**Washington State
Department of Transportation**

May 21, 2013

Attention: Jeff Watson, Planner
Subject: BL-13-00007 – Grossman – SR 97, milepost 142.60 right

BOUNDARY LINE ADJUSTMENT SURVEY
PREPARED FOR
ROD GROSSMAN
A PORTION OF THE SW 1/4 OF THE NW 1/4 AND THE NW 1/4 OF THE SW 1/4,
OF SECTION 25, TOWNSHIP 19 NORTH, RANGE 17 EAST, W.M.
KITITAS COUNTY WASHINGTON

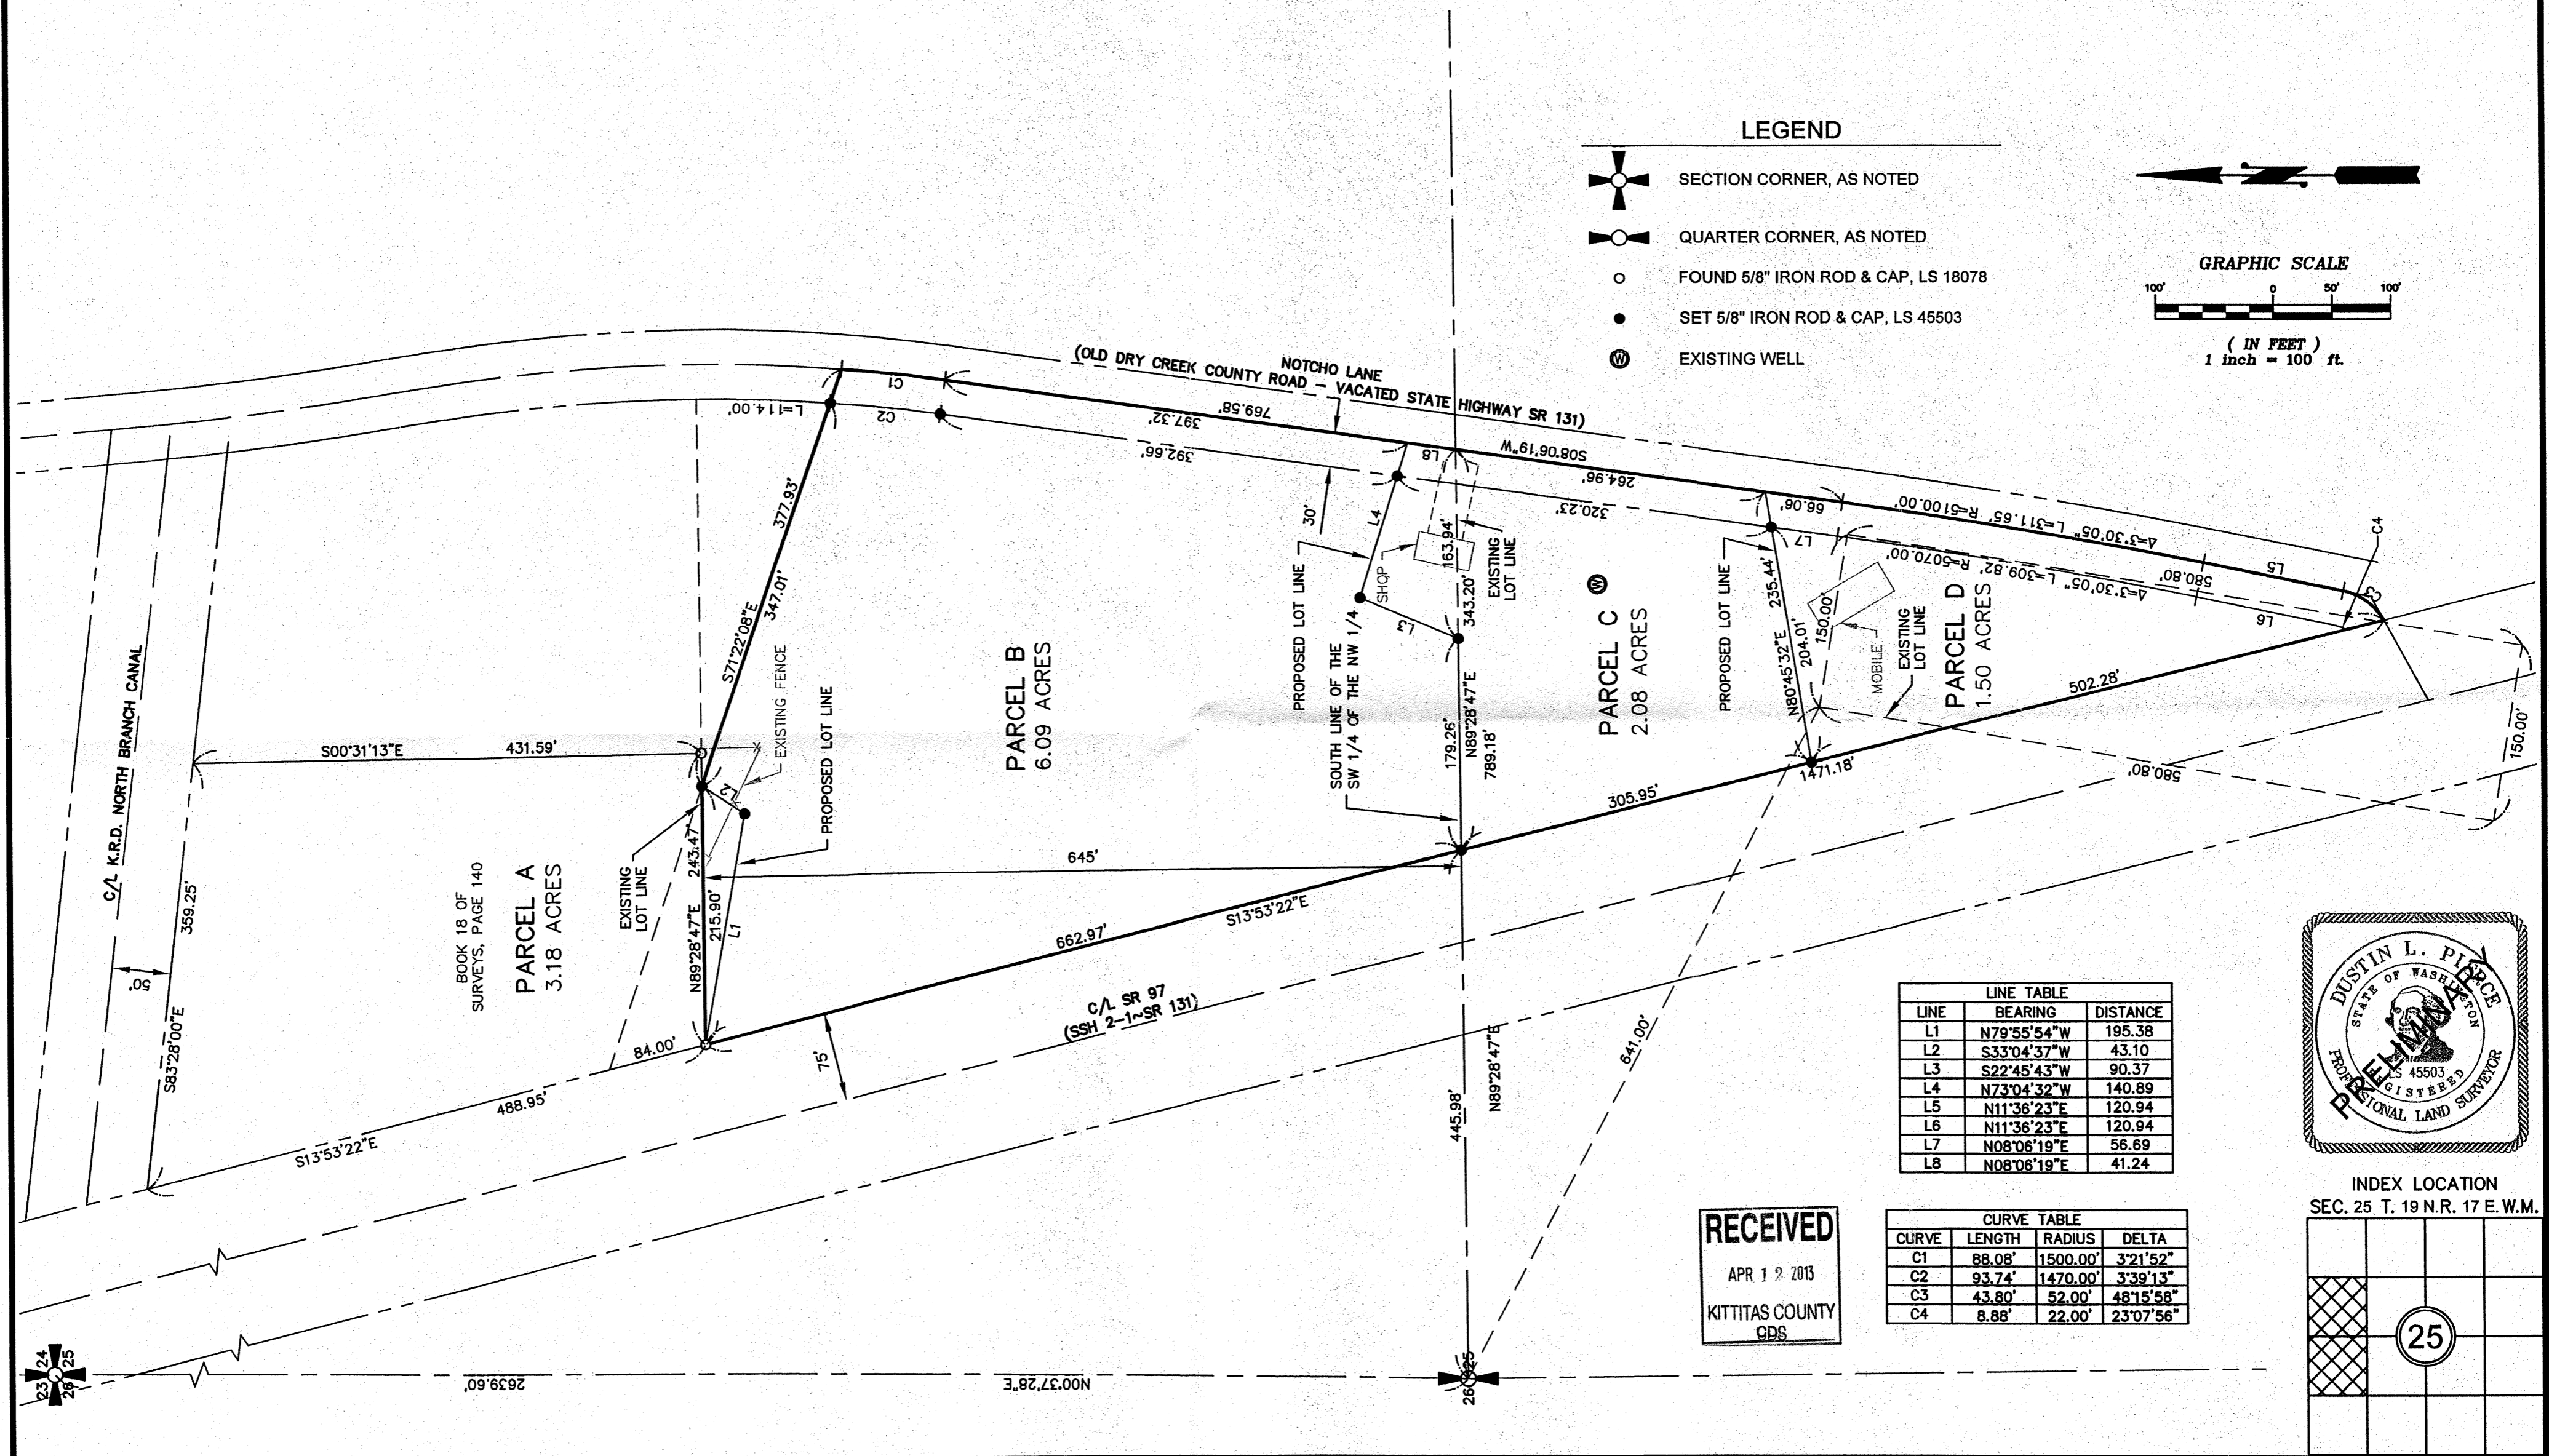
- The property is adjacent to U.S. Highway 97 (US 97), a Class 1 managed access facility with a posted speed limit of 65 miles per hour. Class 1 highways favor mobility over access to adjacent properties. WAC 468-52-040 and others stipulate, "if access is available via the general street system, primary access shall be provided from the general street system rather than from the state highway." No more than one access is allowed for contiguous parcels under the same ownership.

- The former State Route 131 (SR 131) runs along the east side of the property. This portion of SR 131 was relinquished to the County. The County then vacated this right-of-way without providing an access easement to abutting properties. Notcho Lane remains a public at-grade intersection within WSDOT right-of-way.

- According to our records, parcels "B", "C", and "D" are under the same ownership; this is the only property owner with the legal right to access US 97 via Notcho Lane. Parcel #19-17-25020-0011, though unrelated to this proposal, has no legal means of access to the highway. Without an established access easement, the right to use Notcho Lane will remain solely with the owner of parcel "D".

In summary, we require an access easement be reserved from Notcho Lane to serve parcels "A", "B", "C", and "D" of this boundary line adjustment as well as parcel #19-17-25020-0011. No new approaches to US 97 will be allowed.
